**KIRKLEES METROPOLITAN COUNCIL
INVESTMENT & REGENERATION SERVICE**

DELEGATED DECISION TO DETERMINE PLANNING APPLICATIONS

Reference No:	2021/62/94607/W
Site Address:	48, Hill Grove, Salendine Nook, Huddersfield, HD3 3TL
Description:	Erection of single storey side extensions
Recommending Officer:	Laura Yeadon

DECISION - REFUSED

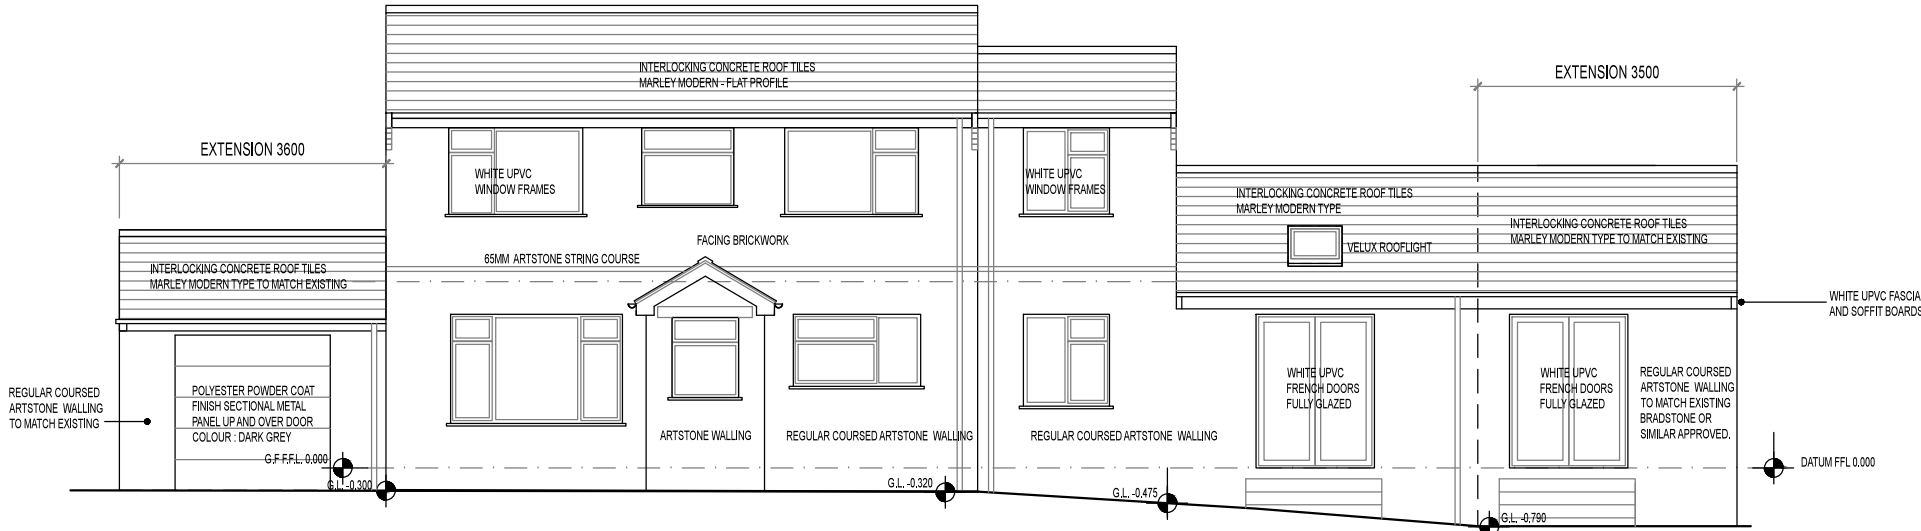
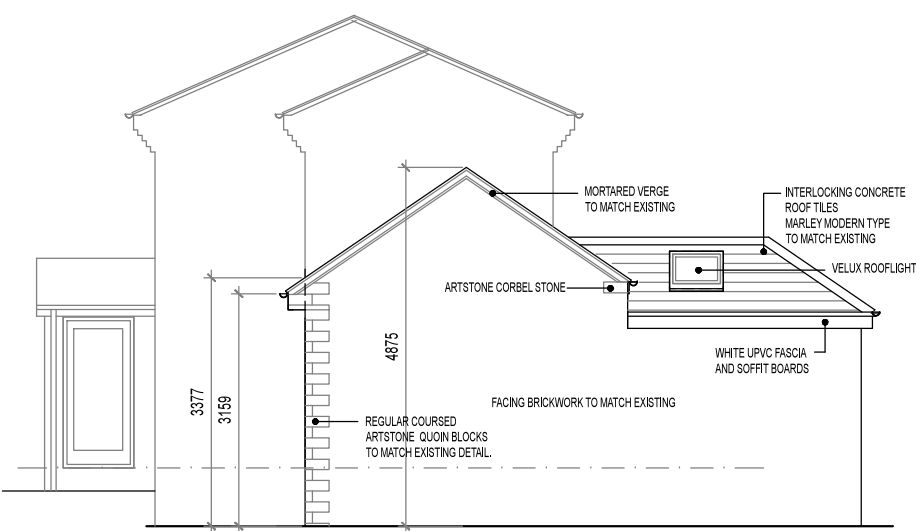
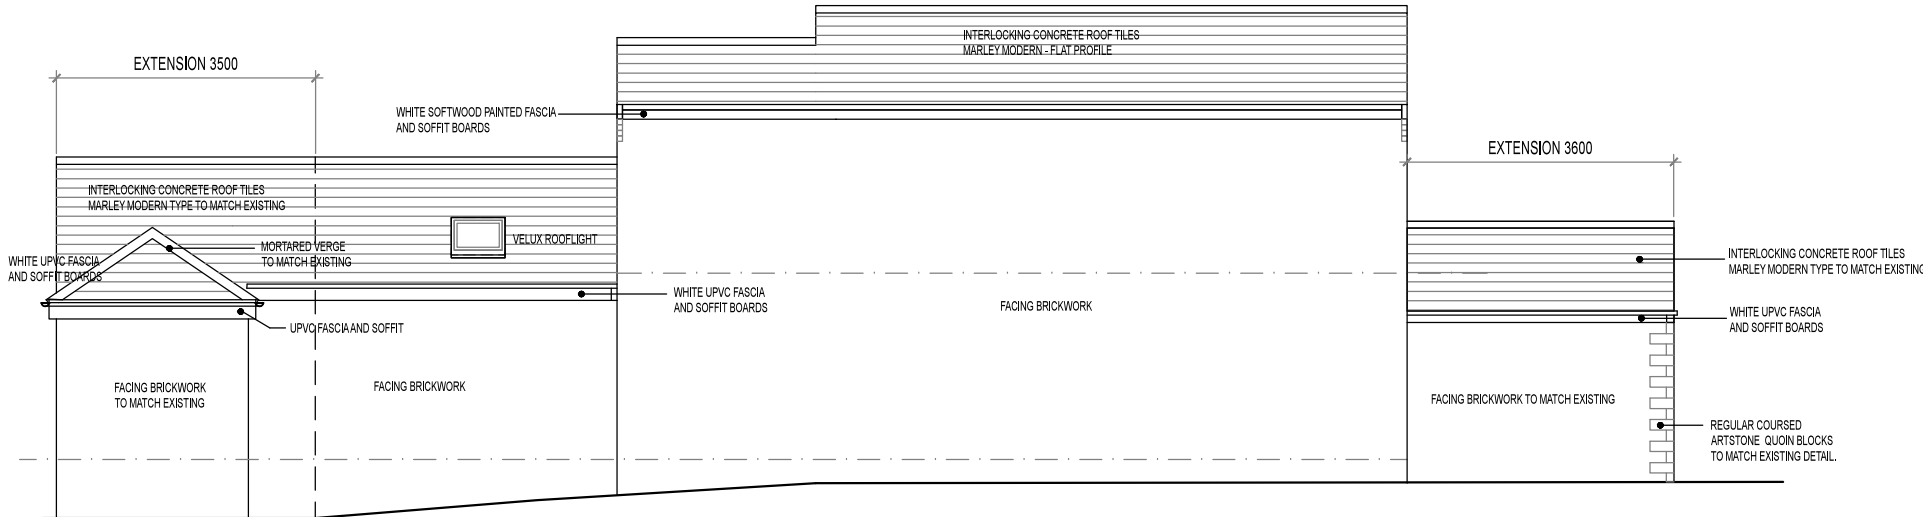
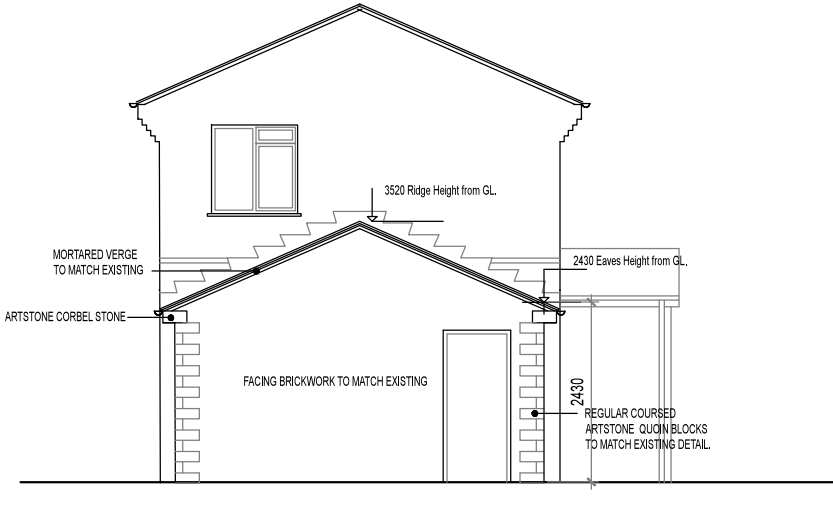
The extension to the north-eastern elevation of the property is proposed to be for garage provision. The garage would be set back from the front elevation of the property by 0.2 metres and would span the depth of the property at 4.9 metres being set in from the rear elevation by 0.2 metres. The extension would project to the side by 3.6 metres and would have an eaves height of 2.3 metres and overall height of 3.4 metres to the ridge of the lean-to roof. The proposed construction materials would be regular coursed artstone for the front elevation with facing brickwork for the side and rear elevations with stone quoins. The roof would be constructed from interlocking roof tiles to match the existing roof.

The extension to the south-eastern elevation would replace the existing garage. The existing boundary wall would be demolished and the extension would infill the existing space between the side of the existing extension and the boundary with the adjacent property No. 46 Hill Grove. The extension would project to the side by 3.5 metres and span the full depth of the property projecting 2.85 metres off the rear elevation of the property at a width of 2.6 metres. The extension would have an eaves and ridge height to match the existing extension with the rear element of the extension having a hipped roof which would be set down from the proposed ridge by 0.9 metres. The

proposed construction materials would be regular coursed artstone for the front elevation with facing brickwork for the side and rear elevations with stone quoins. The roof would be constructed from interlocking roof tiles to match the existing roof.

No amendments were sought as it was not considered that there would not be a design solution to overcome concerns and provide the level of accommodation proposed. It is also noted that the proposed plans indicate a scale of 1:50 however when measured against the annotations on plan, these are to a scale of 1:100.

The House Extensions and Alterations SPD states that single storey side extensions should not extend more than two thirds of the width of the original house; not exceed a height of 4 metres; and should be set back at least 500mm from the original building line to allow for a visual break. In this instance, due to the existing extension and the width of the extensions and existing extensions would exceed half the width of the original house, the extension adjacent to No. 46 would be higher than 4 metres due to topography and also the bedroom would lie flush with the existing extension and would not be set back. As such, the proposal would fail to meet the requirements of the SPD with regards to visual amenity.

The property is located within a corner plot and the SPD is clear in that extensions should be set in from the established building lines and create a frontage. In this instance, the proposed garage extension would project forward of the front elevation of No. 50 Hill Grove which is not considered to be good design with no features of interest within the side elevation and forward of the front elevation and established building line of properties to the east.

2. The proposed extensions by reason of their design, scale, prominence and hard landscape frontages would not appear to be subservient in relation to the host property resulting in development which fails to harmonise with the character and appearance of the host dwelling and the wider street scene. To permit the development would be contrary to principles 1 and 2 and paragraphs 5.15, 5.16, 5.17 and 5.23 of the Council's adopted House Extensions and Alterations SPD, Kirklees Local Plan Policy LP24 parts (a) and (c) and paragraph 130 parts (a) and (c) of the National Planning Policy Framework.

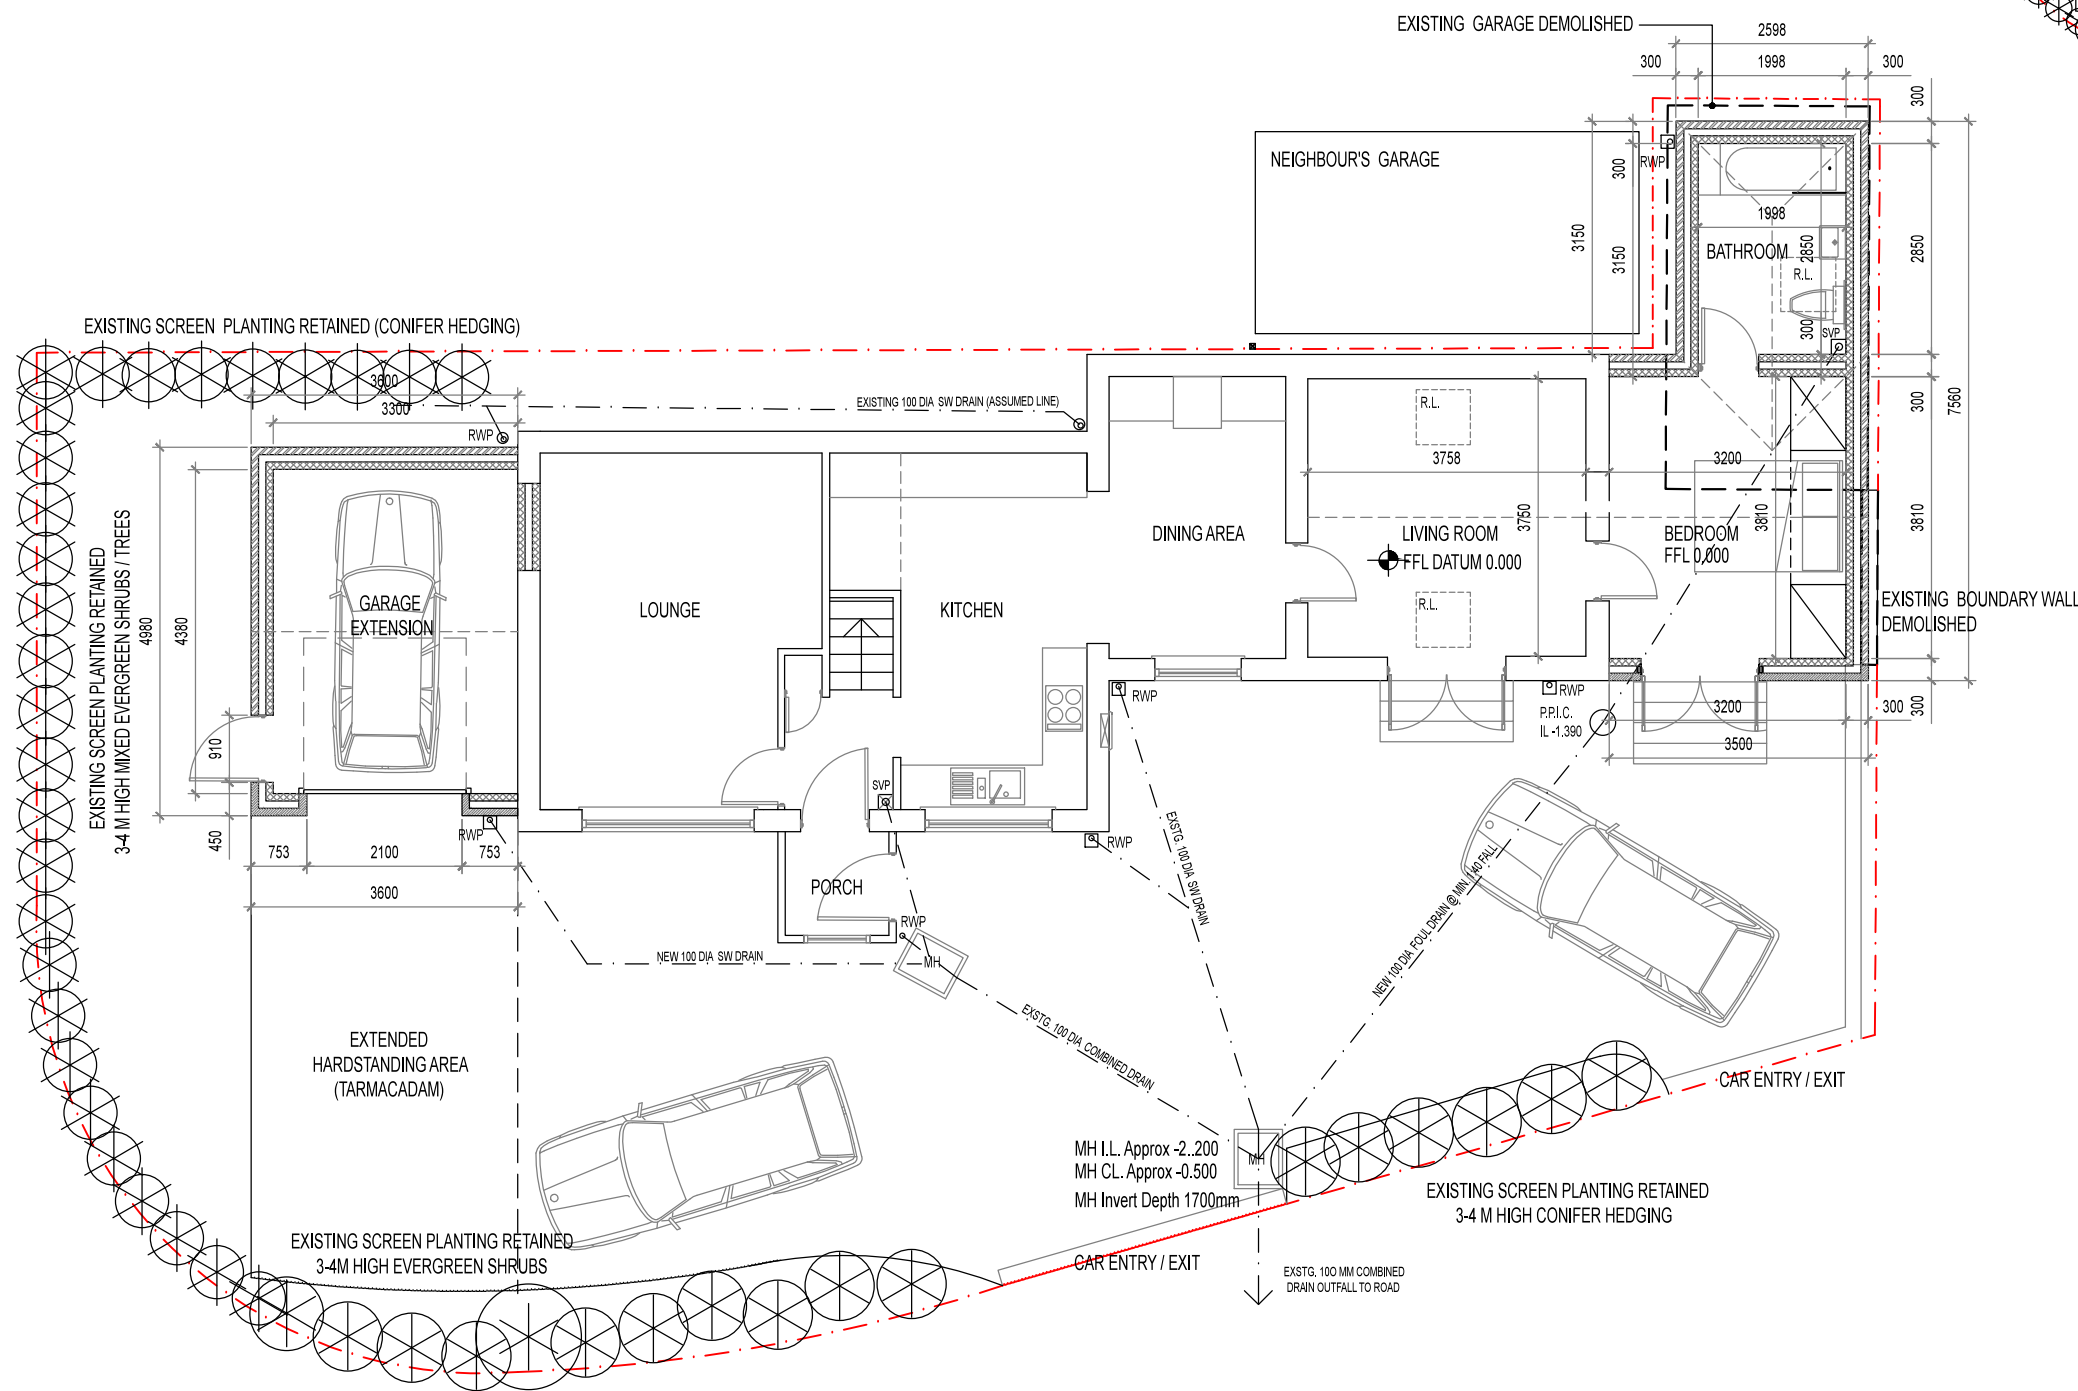
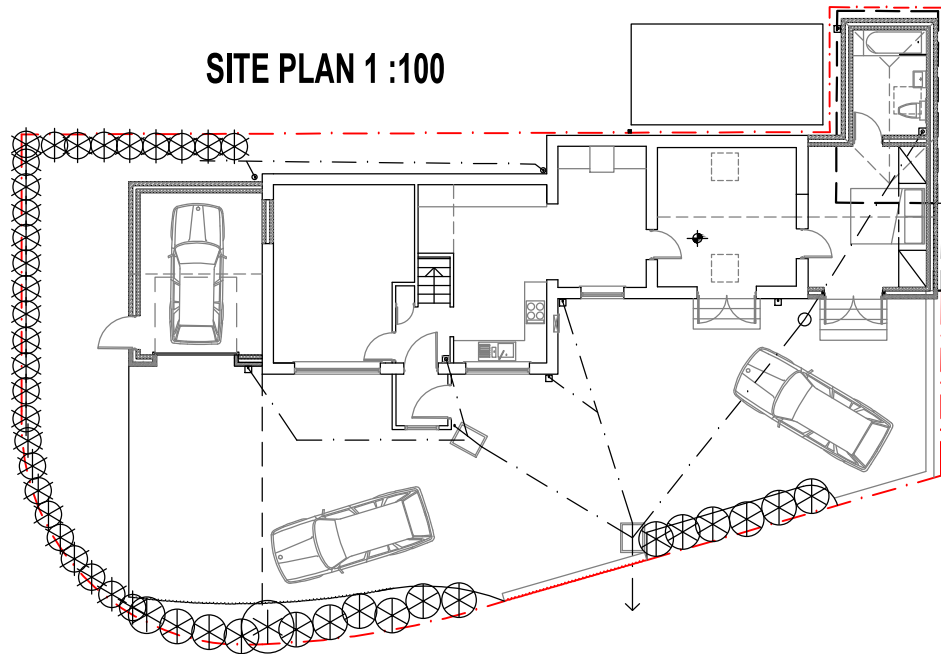
It is also proposed that the area to the front of the proposed garage would be extended tarmac being a width of 3.8 metres and depth of 5 metres. It is proposed the existing screening would be retained.

Due to the loss of the amenity area for the property with the garage extension and associated hardstanding area it is considered that the works would result in an overdevelopment of the plot with no meaningful amenity area for existing and future occupiers which is considered to be contrary to policy LP24 and principle 7 of the House Extensions and Alterations SPD. The site has been developed in a manner which has removed the majority of amenity space already, the proposal would see the all of the amenity space available replaced with built form and hardstanding.

The existing garage provision would be lost as a result of the proposal however parking provision is proposed within the new garage. The existing garage does not meet the required dimensions as required within the Kirklees Highways Design Guide and neither does the proposed garage and therefore, there would be no loss of parking provision. There is sufficient space within the site frontage to accommodate 3 no. vehicles which is in accordance with the standard for a dwelling with 4+ bedrooms.

In terms of the proposed hardstanding area to the front of the garage, whilst it is noted that there is existing tarmac to the front of the property, it is considered necessary that any new hardstanding would need to be permeable surfacing to prevent issues relating to surface water and in the event of any grant of permission it is recommended this is ensured by inclusion of an appropriately worded condition.

1. The cumulative impact of the existing and proposed extensions, given the modest curtilage of the host dwelling would result an overdevelopment of the site with insufficient amenity space remaining for the future occupiers. To permit the development would be contrary to Policy LP24 b of the Kirklees Local Plan, Key Design Principle 7 of the House Extensions and Alterations SPD and paragraph 130(f) of the National Planning Policy Framework.
